Our ref: HA/2019/121334/01-L01
Your ref: LU/126/19/PL
Date: 07 June 2019

DEMOLITION OF THE EXISTING GARAGE BUILDING (B2 INDUSTRIAL USE) AND REDEVELOPMENT OF THE SITE PROVIDING 9NO C3 RESIDENTIAL UNITS - THIS APPLICATION AFFECTS THE CHARACTER AND APPEARANCE OF RIVER ROAD CONSERVATION AREA.

25 RIVER ROAD LITTLEHAMPTON BN17 5BZ

01 Ground Floor

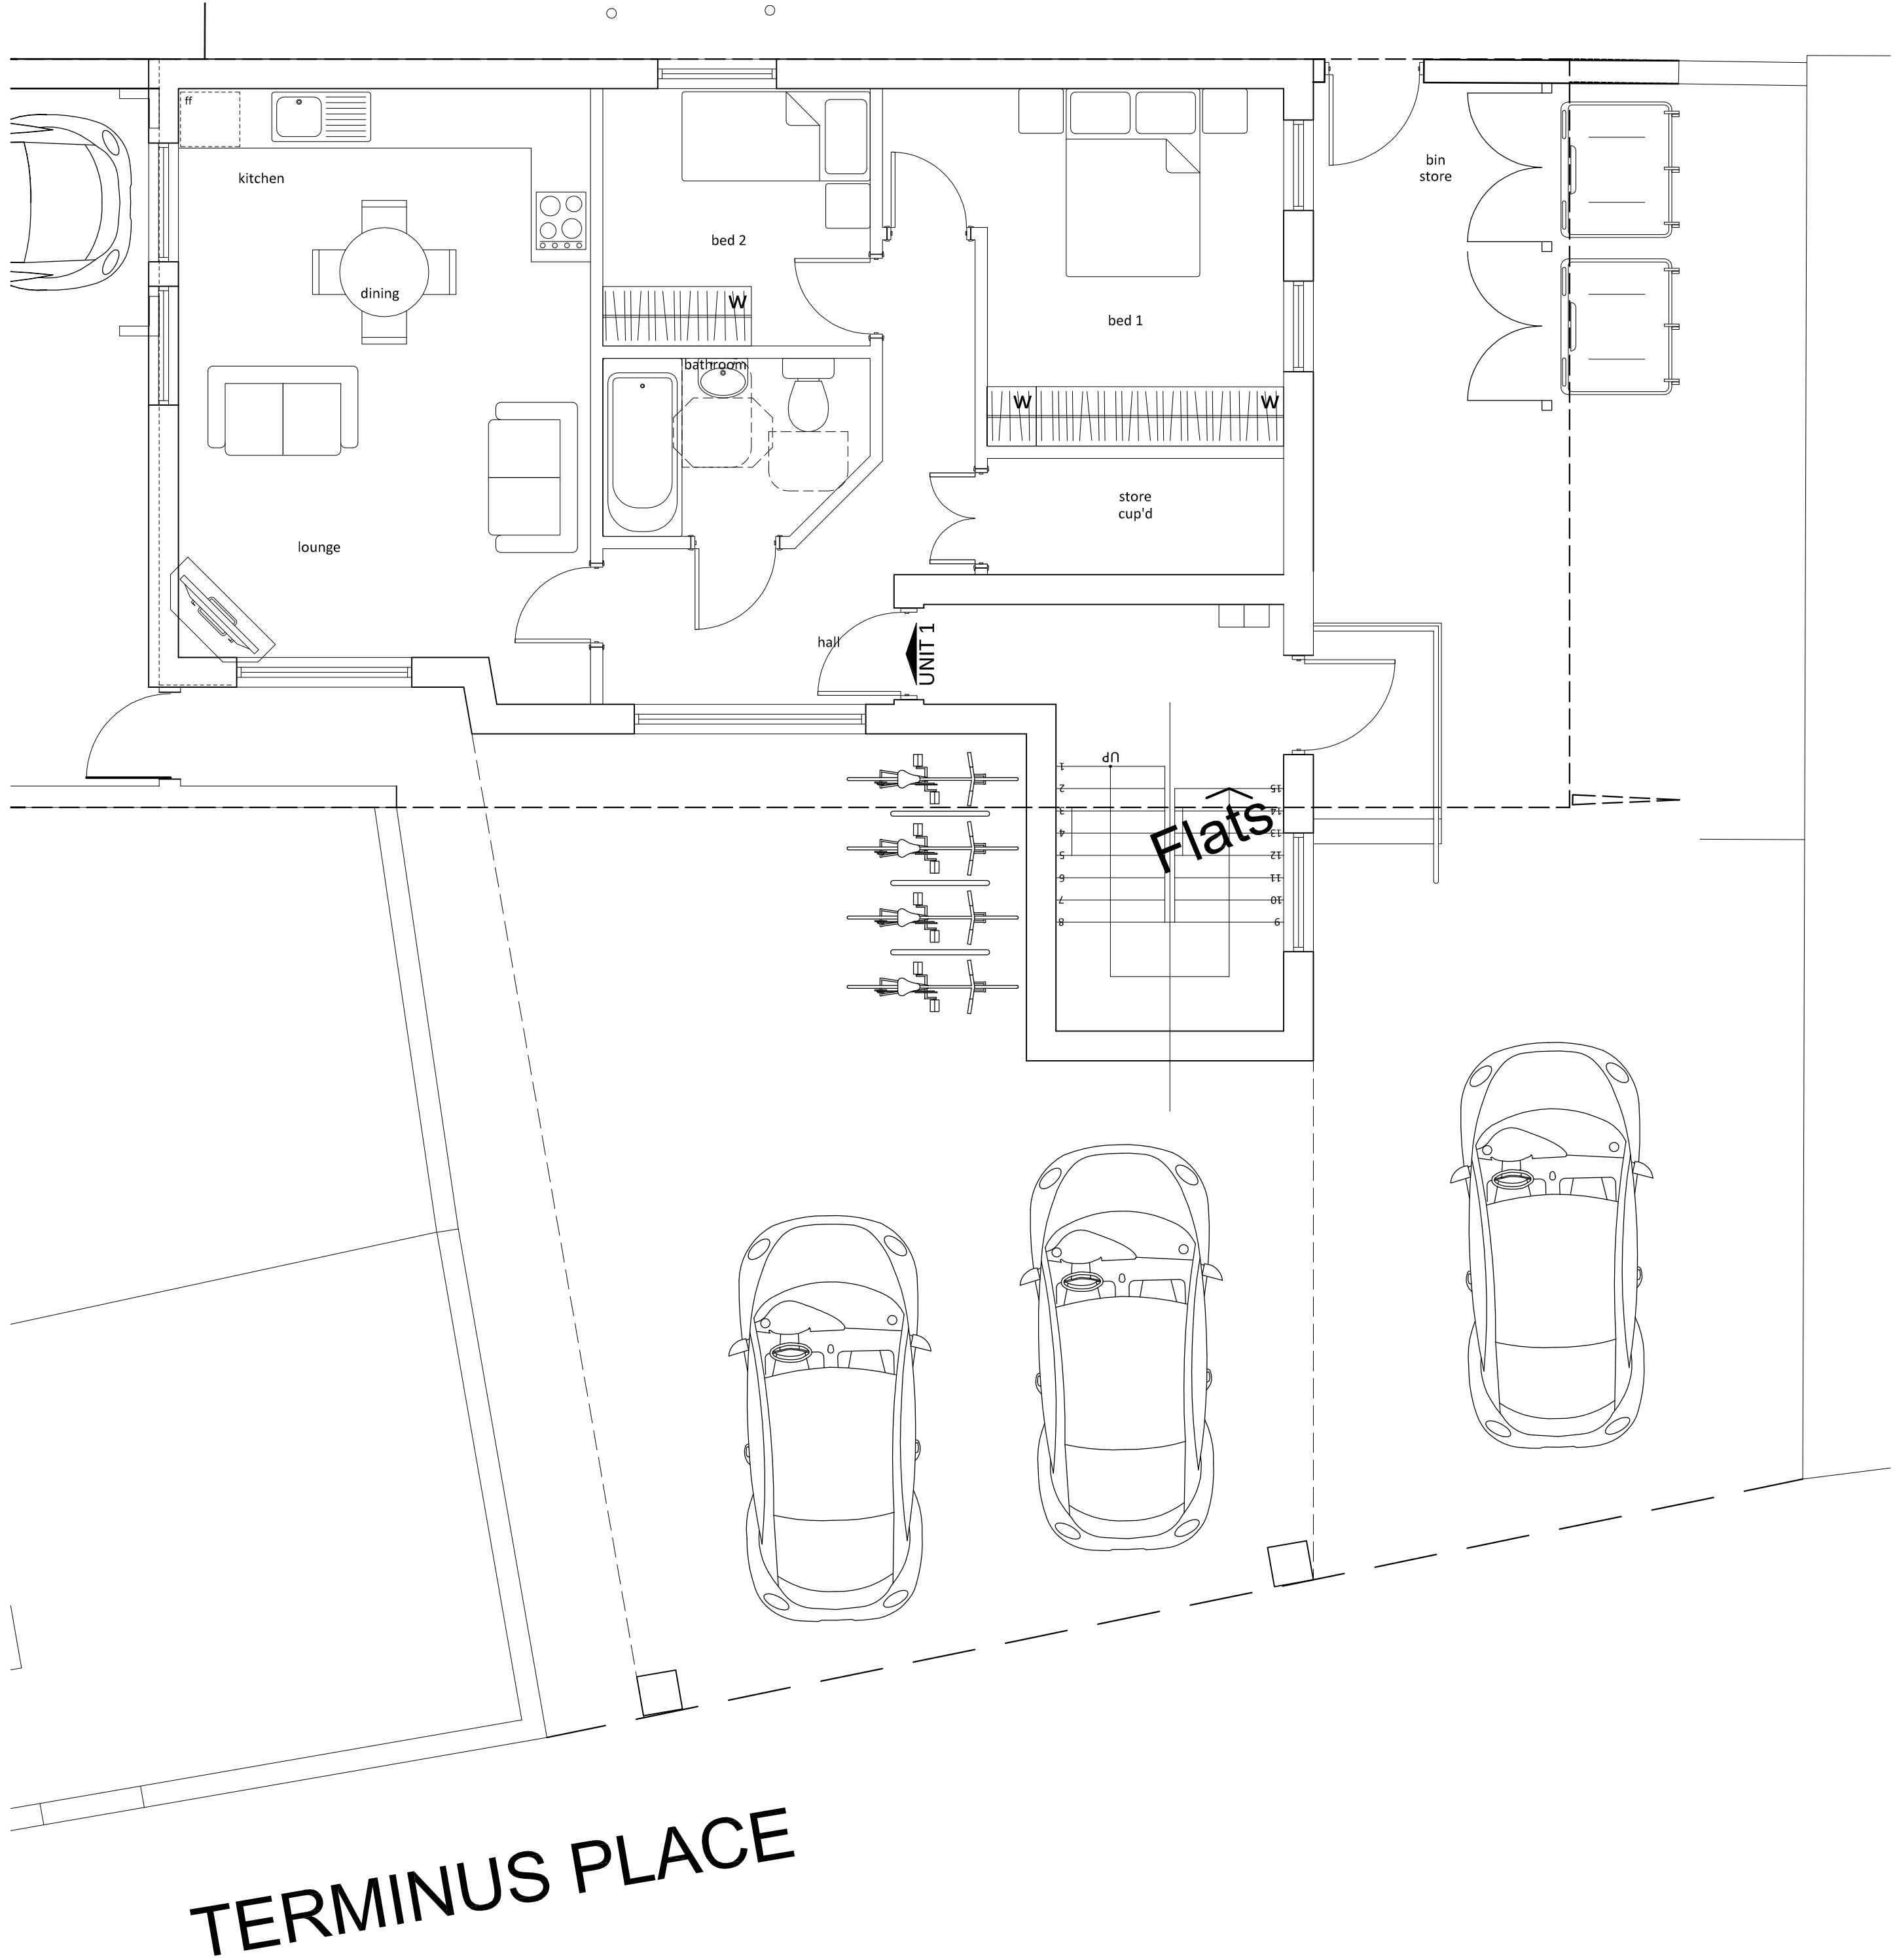
- Consider finished floor levels in relation to flood levels and depths during the lifetime of the development taking in account climate change allowances.
- Ensure that no habitable rooms are placed below the 0.5% AEP 2115 flood level.

We would advise that the proposed design for the river road site, with habitable accommodation placed on the first floor and above is adopted for the Terminus Road side of the development in a revised design.

To overcome our objection, the applicant should submit a revised FRA which addresses the point highlighted above, they may also wish to apply for a product 4 data pack from the Environment Agency to inform the application.
